**Comments on Environmental Statement – Chapter 5: Project Description – Draft
March 2023 – issued to the LPA on 28 April 23**

DRAWING NO. FIGURE 5.2.1a	REVISION For ES Issue
	DRAWN BY MS	PM / CHECKED BY KC

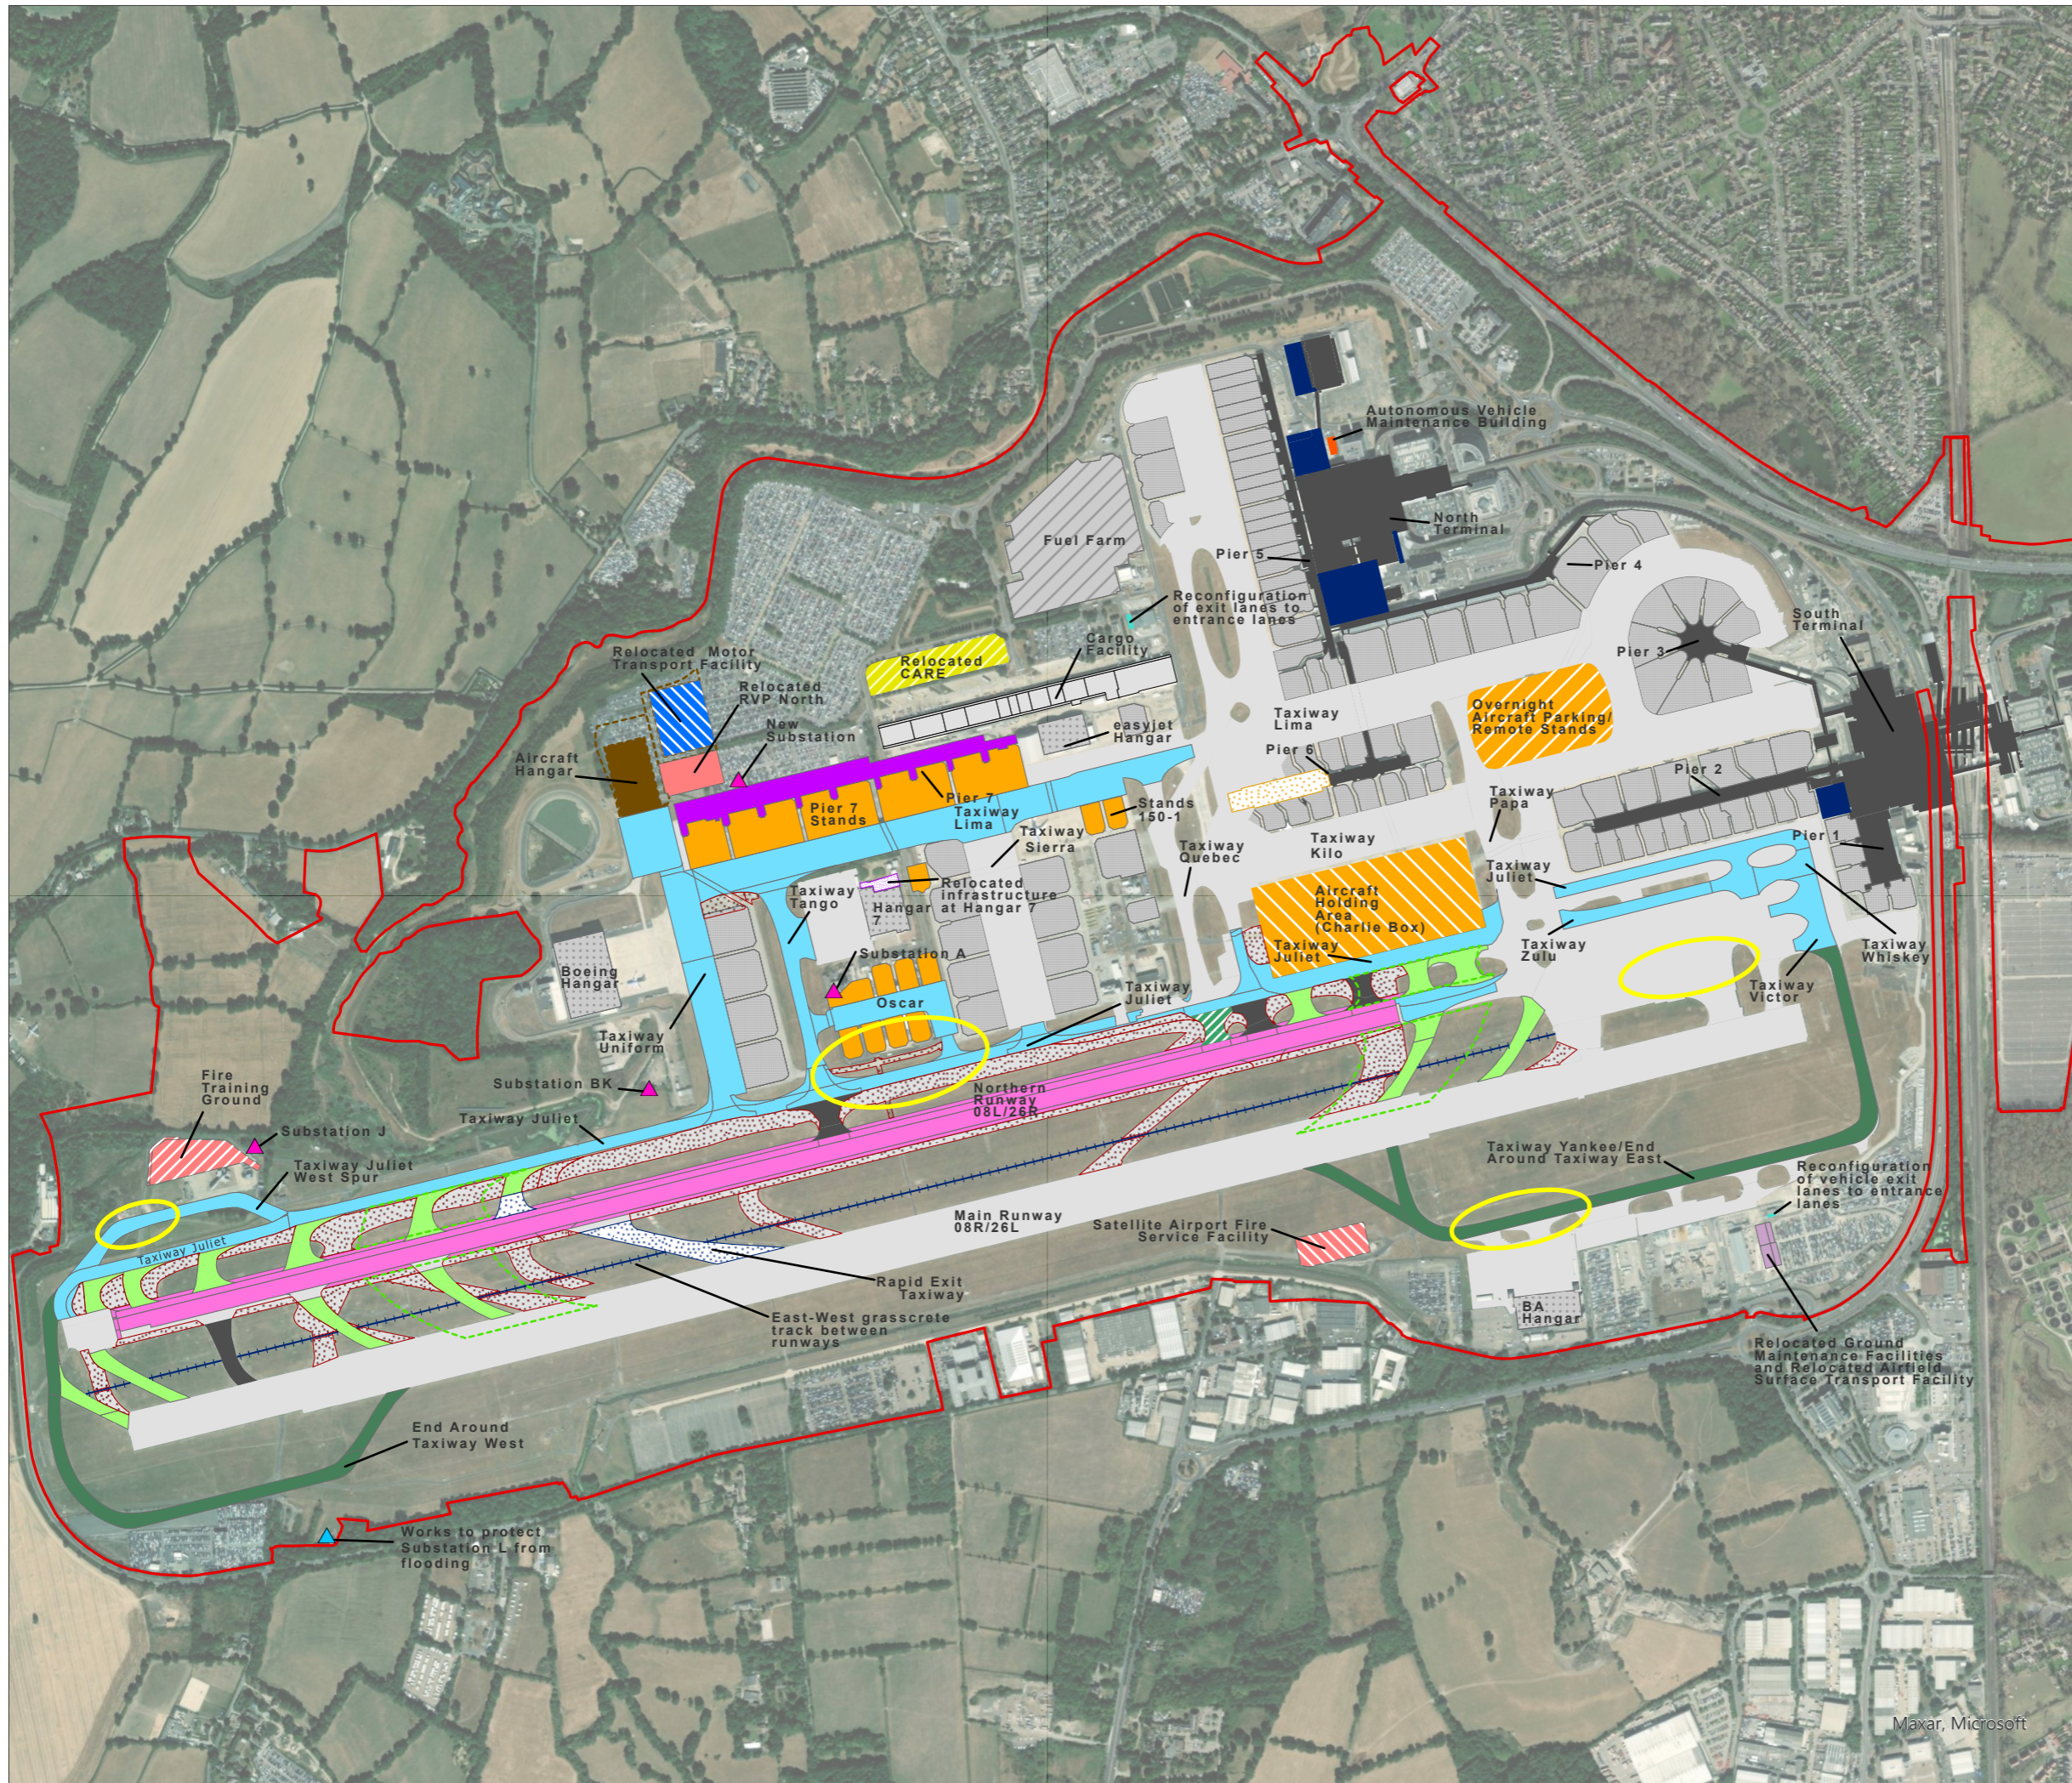
5.2.48	The yellow circled areas are not explained on 5.2.1 a
5.2.66	New office block (4,580sqm lettable floor area) – we assume this is to replace the lost floorspace at Destinations Place (as GAL has previously advised at TWGs) but the ES does not explain this.

5.1.126	Museum Field – another example where it is unclear what the works area and how this all works with drainage etc
5.2.117 & 5.3.49	<p>The ES sets out that if there is not sufficient capacity within the existing Crawley WwTW to meet demand arising from the Project, an expansion may be required. We understand that Crawley WwTW is already close to capacity and will require upgrades to accommodate planned growth outside of the DCO. On this basis, has GAL received feedback from Thames Water as to what upgrades may be required, and when these would need to be in place?</p> <p>5.3.49 sets out that 'the proposed water treatment works are anticipated to be constructed during 2027 to 2028'. It is unclear if this relates to the existing Crawley WwTW or is something separate proposed by GAL to accommodate needs arising from the Project.</p>
Figures	
Fig 5.2.1a	Unclear which extensions are which on the terminal buildings

ORIENTATION 	DRAWING NO. FIGURE 5.2.1b	REVISION For ES Issue
	DRAWN BY MS	PM / CHECKED BY KC

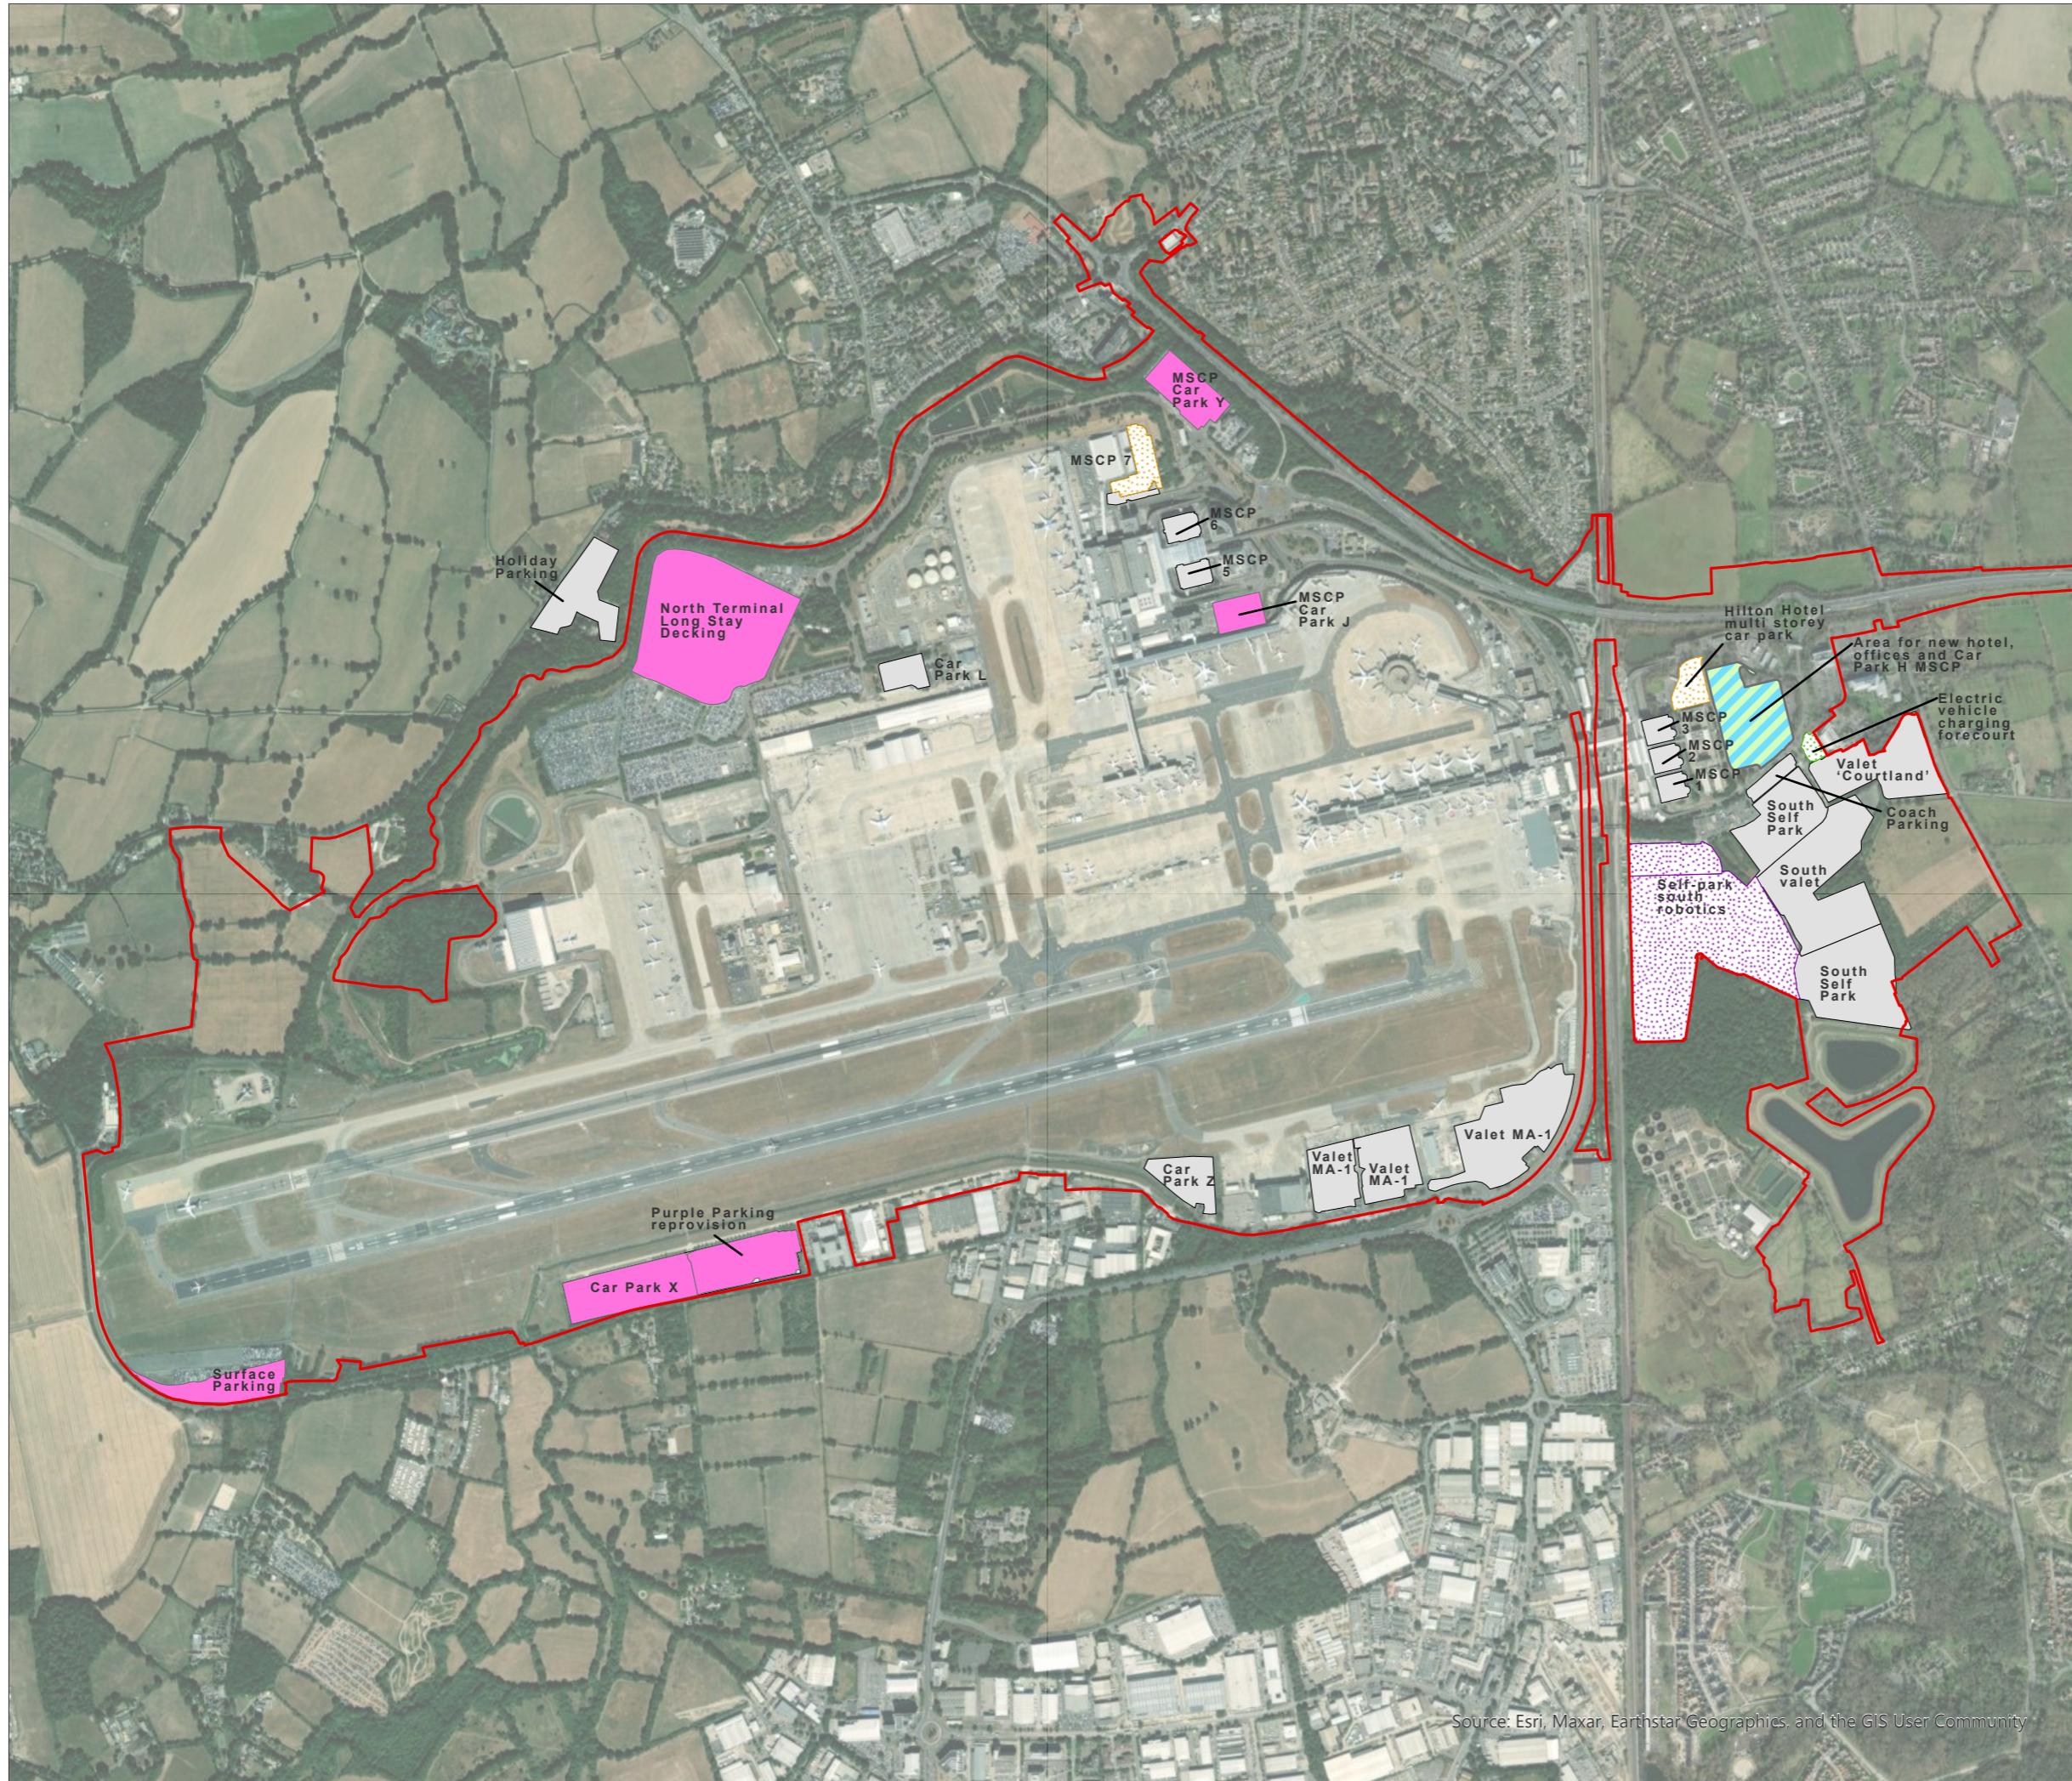
5.2.68	The car parking provision and numbers are still not easy to follow in this document. While there is a parking plan it still does not clearly explain the car parks or where things are. Where is summer special? How will the new/reprovision reflect the provision of parking at a range of different price points? The ES refers to staff and passenger car parking interchangeably. It would be helpful if Table 5.2.3 could delineate between staff and passenger parking.
